National Highways Planning Response (NHPR 25-01) Formal Recommendation to an Application for Planning Permission

Council's Reference: 2025/93086

Location: Wappy Springs Inn, Lindley Moor Road, Lindley Moor, Huddersfield, HD3 3TD

Proposal: Discharge of details reserved by condition 21 (fence) on previous permission 2024/92553 for erection of mixed industrial development (Use Classes E(g)(ii, iii), B2 and B8); including demolition of existing structures, new yard, parking, landscaping, drainage features and ancillary structures

CLD Dulok ScreenFence

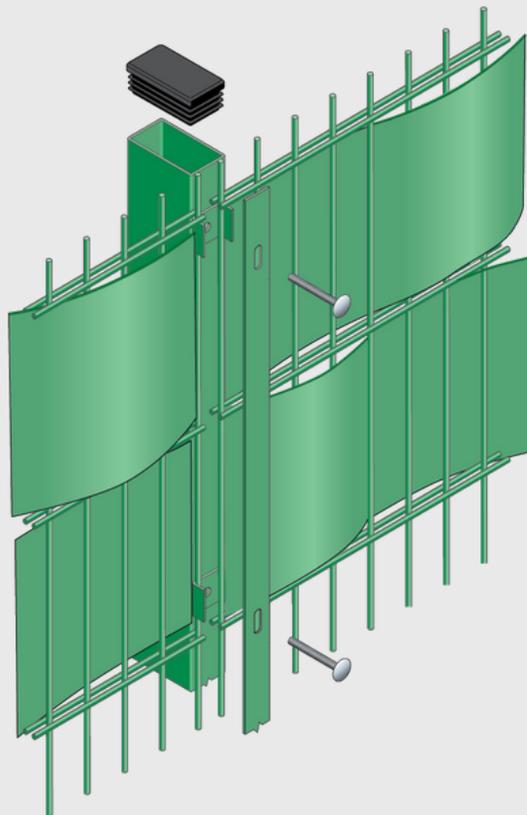
I am content with the use of the alternative CLD Dulok Screen Fence privacy screening system due to its long life and durability.

Drawing Title
FENCING & GATE DETAIL

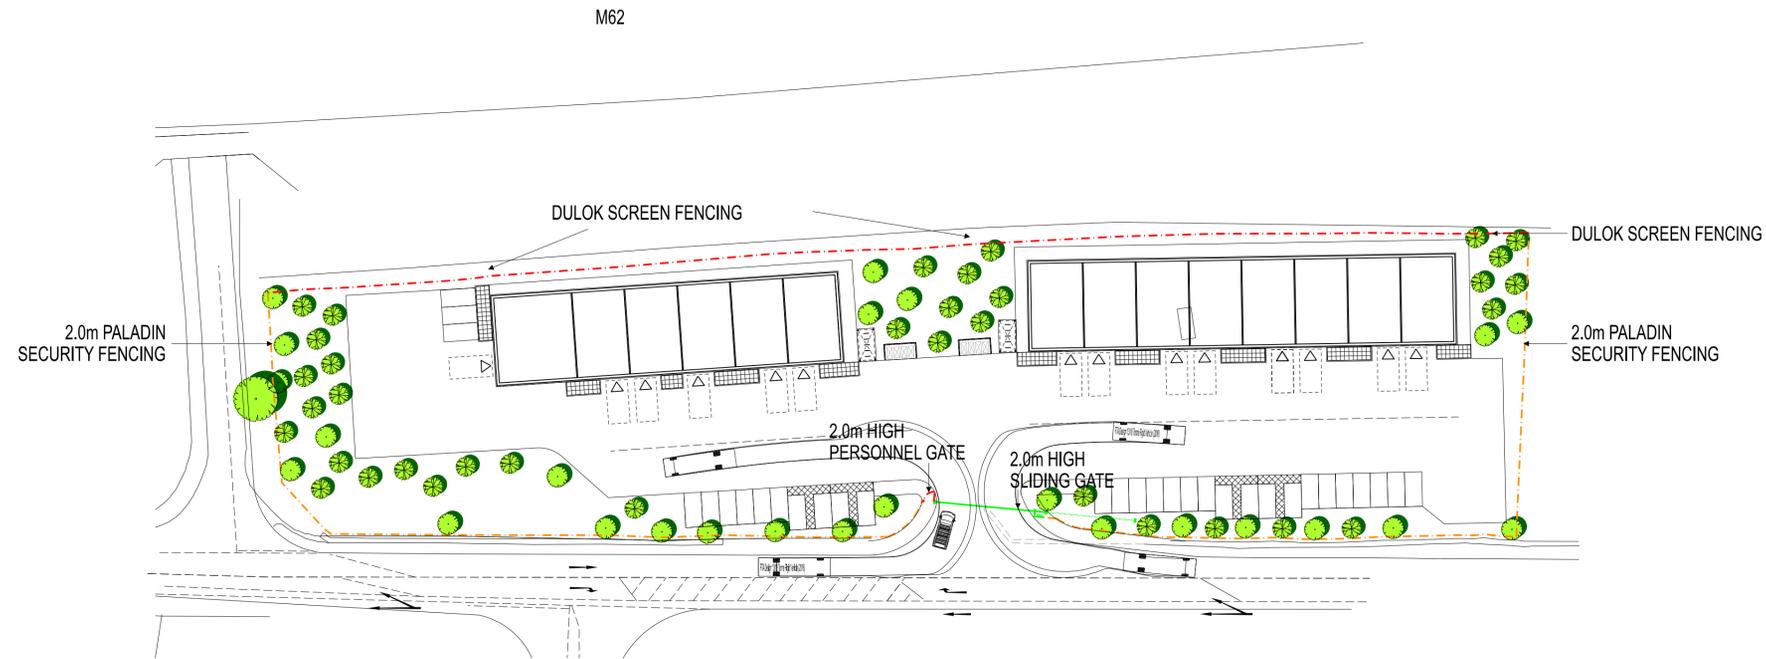
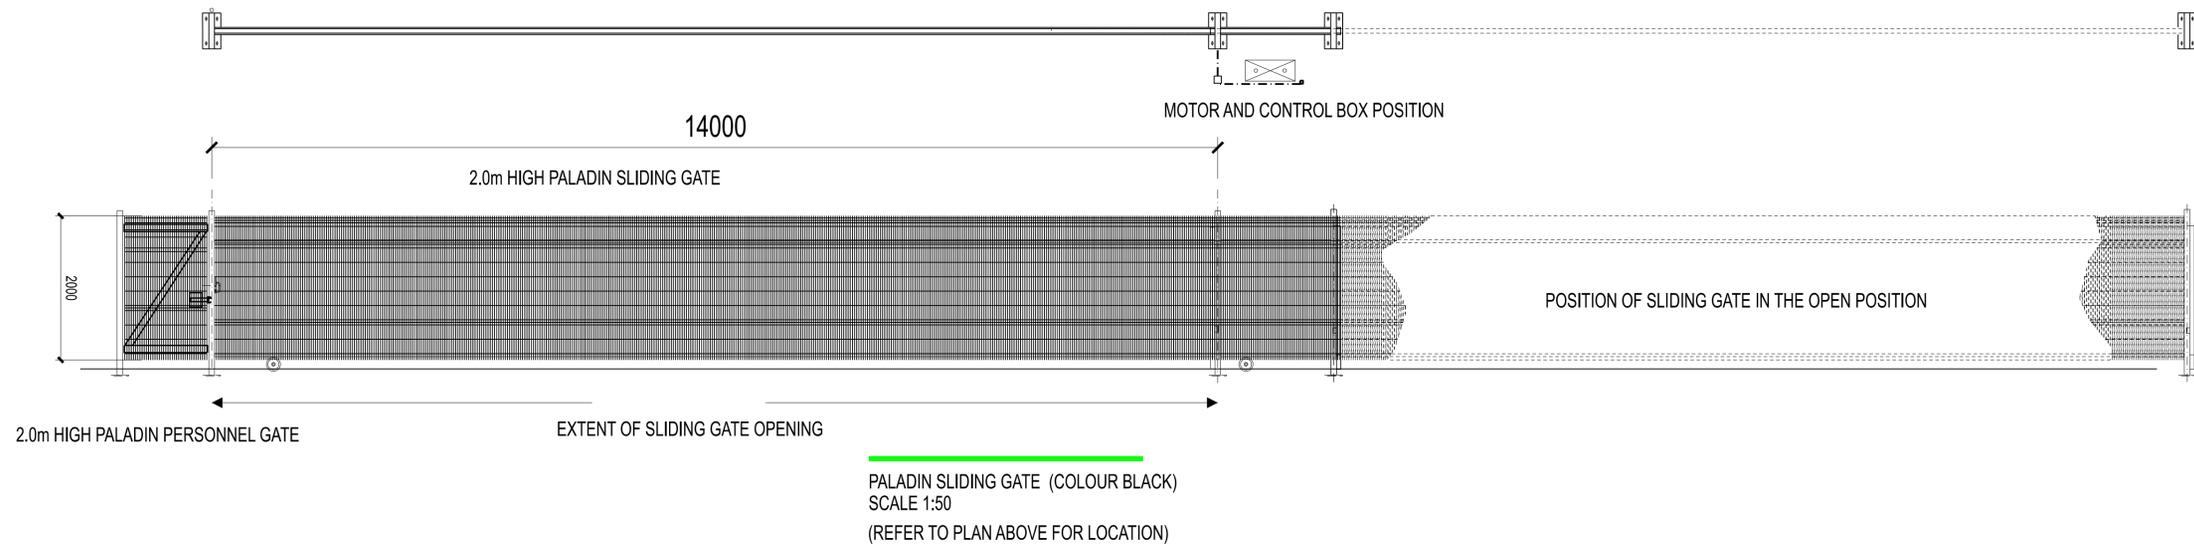
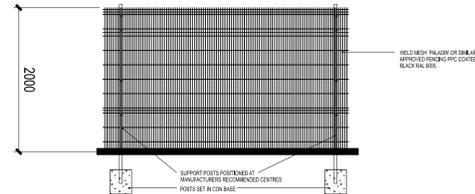
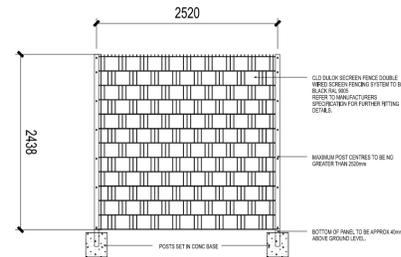
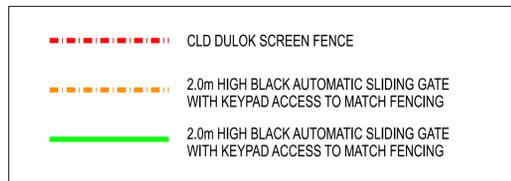
However, a plan showing the alignment of the fence along the boundary of the development site with the M62 (or at least one metre from any part of the existing Motorway fence where the boundary lies within one metre of this) has not been provided as required.

As such, the applicant is asked to provide this to satisfy both National Highways and the Local Planning Authority that all the requirements of this condition are met prior to discharge.
